COLORADO
Department of Transportation

August 24, 2018

RE: PPR1836, Largent Subdivision Big O Tires site development

10 SITE PLAN
SCALE: 1"=30'-0"

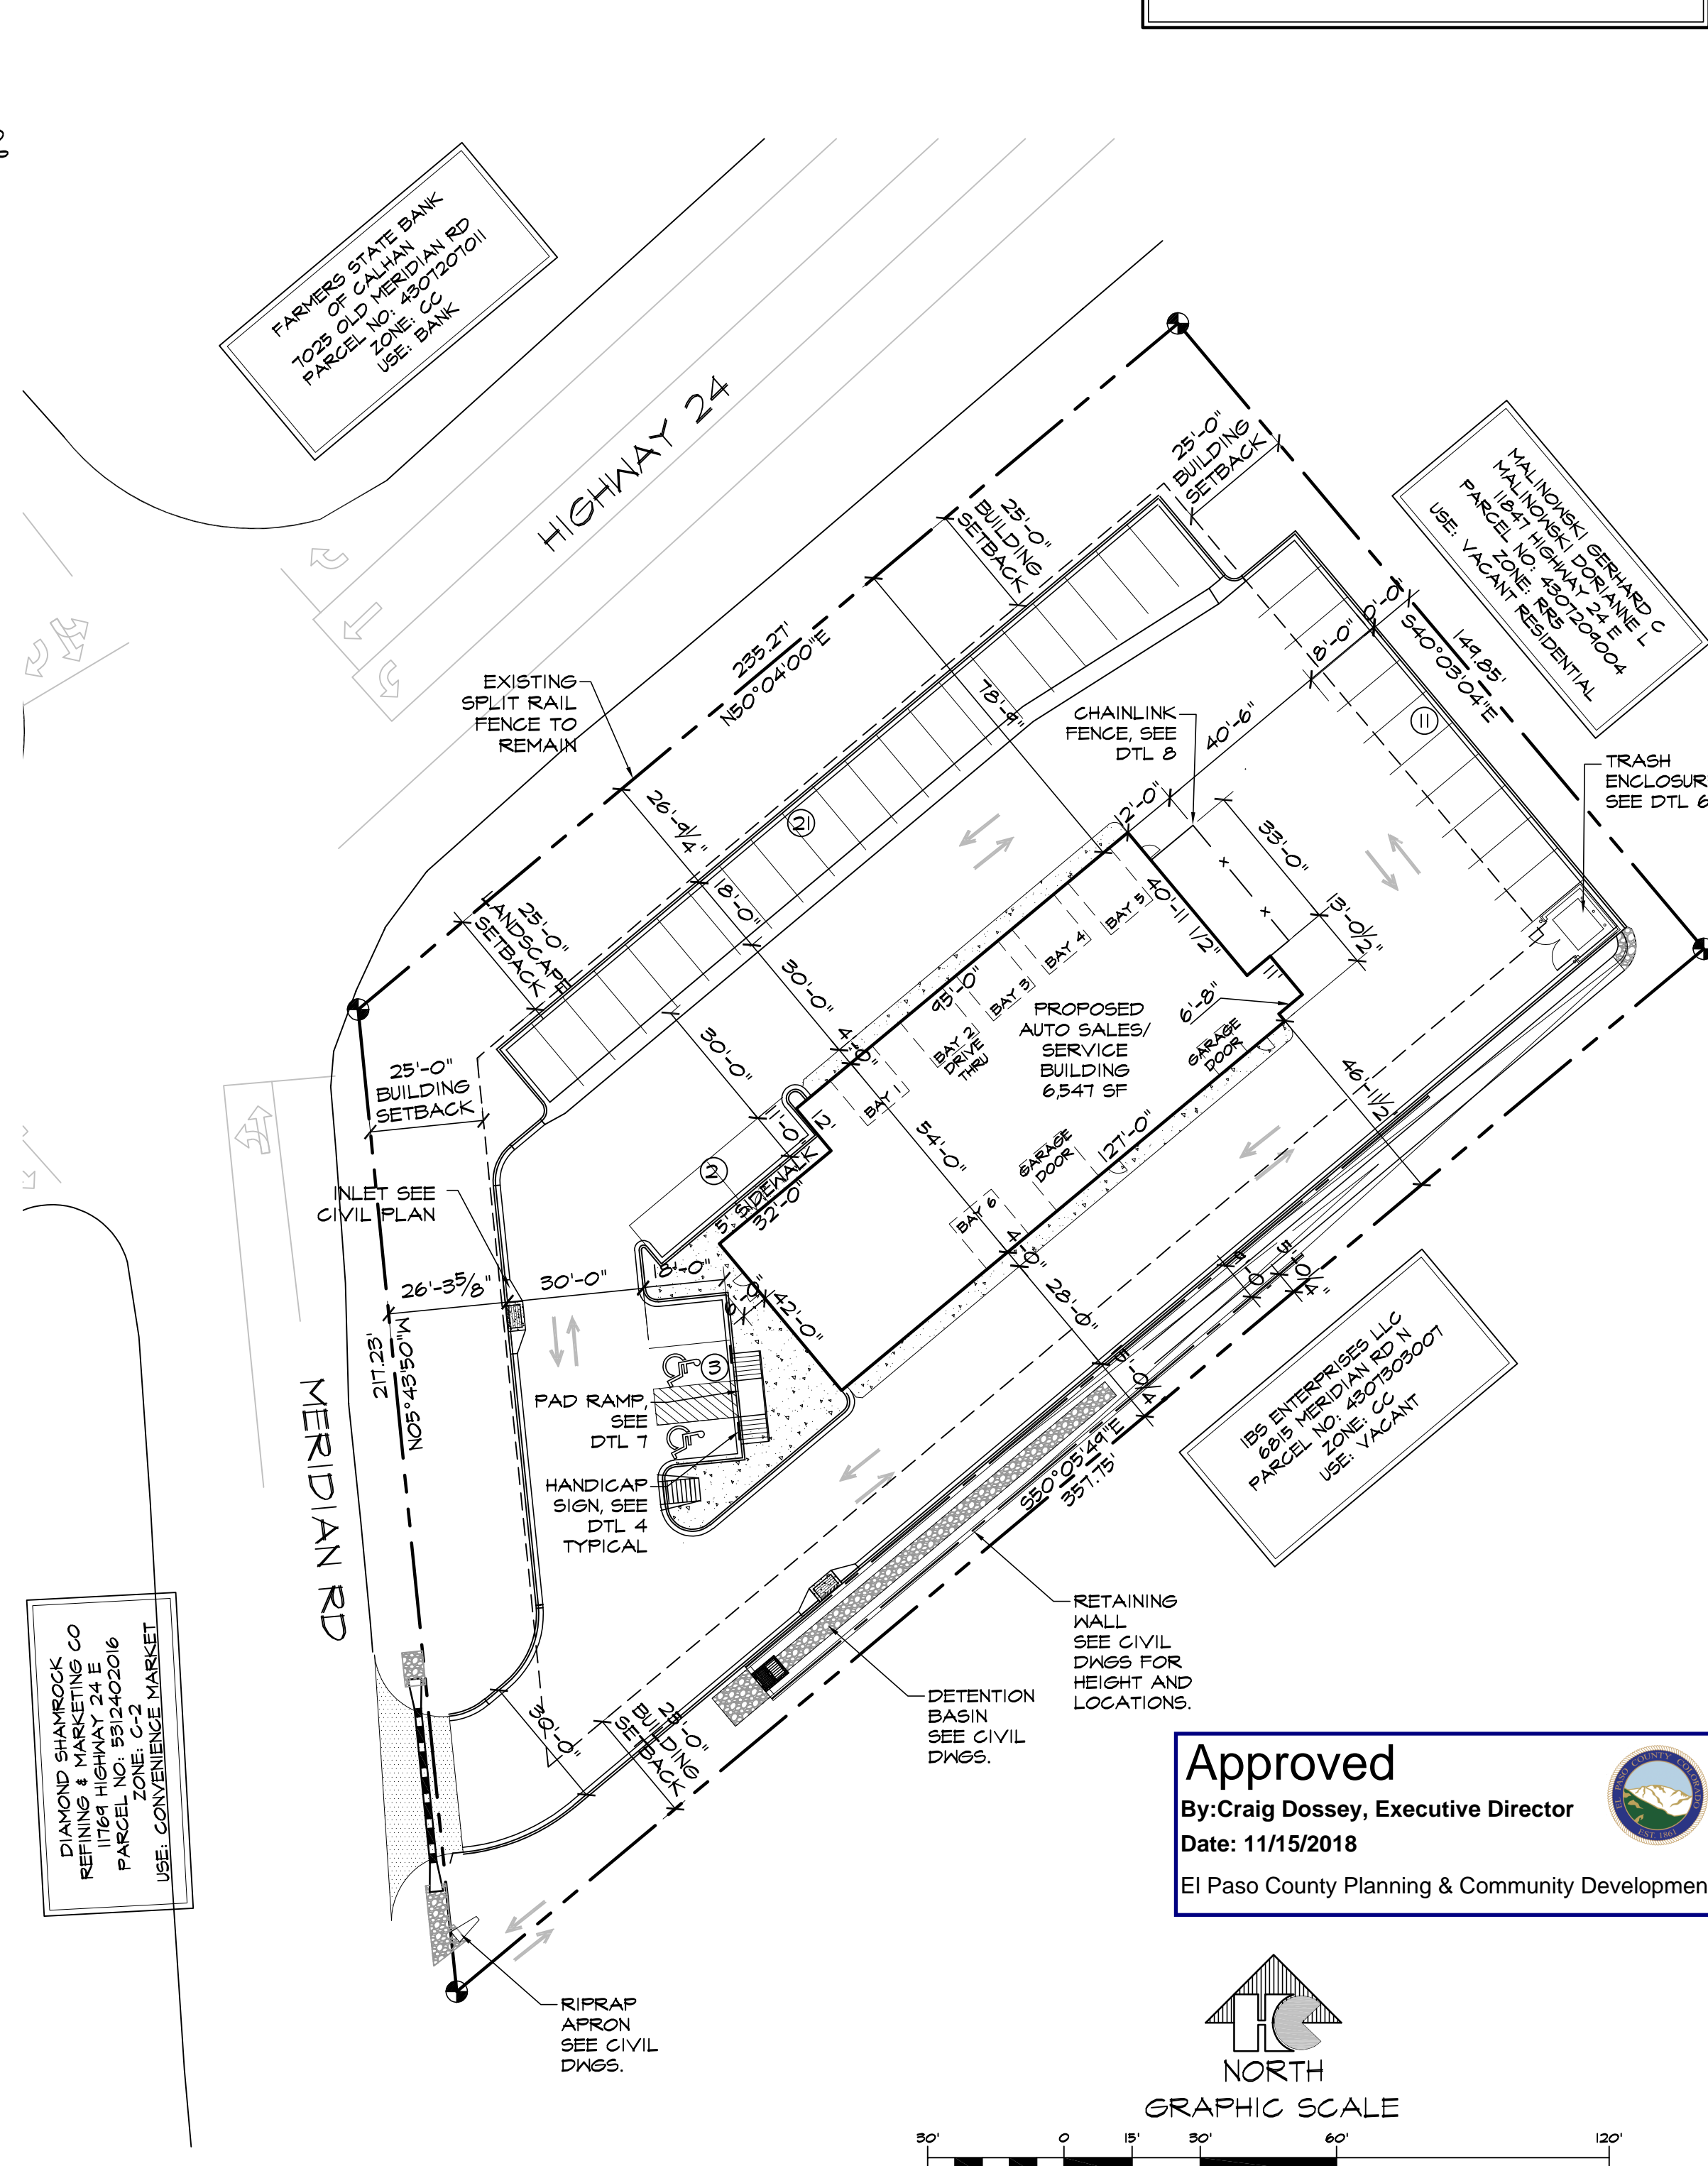
- After discussion and email conversations between CDOT and El Paso County there will need to be a Right-of-Way (ROW) dedication of 225 LF for future expansion of US-24. This 225 LF will need to measure Right-of-Way to Right-of-Way not to include any City or County set back ordinances. An additional 40ft ROW reservation will be required for the no build area beyond ROW to the south.
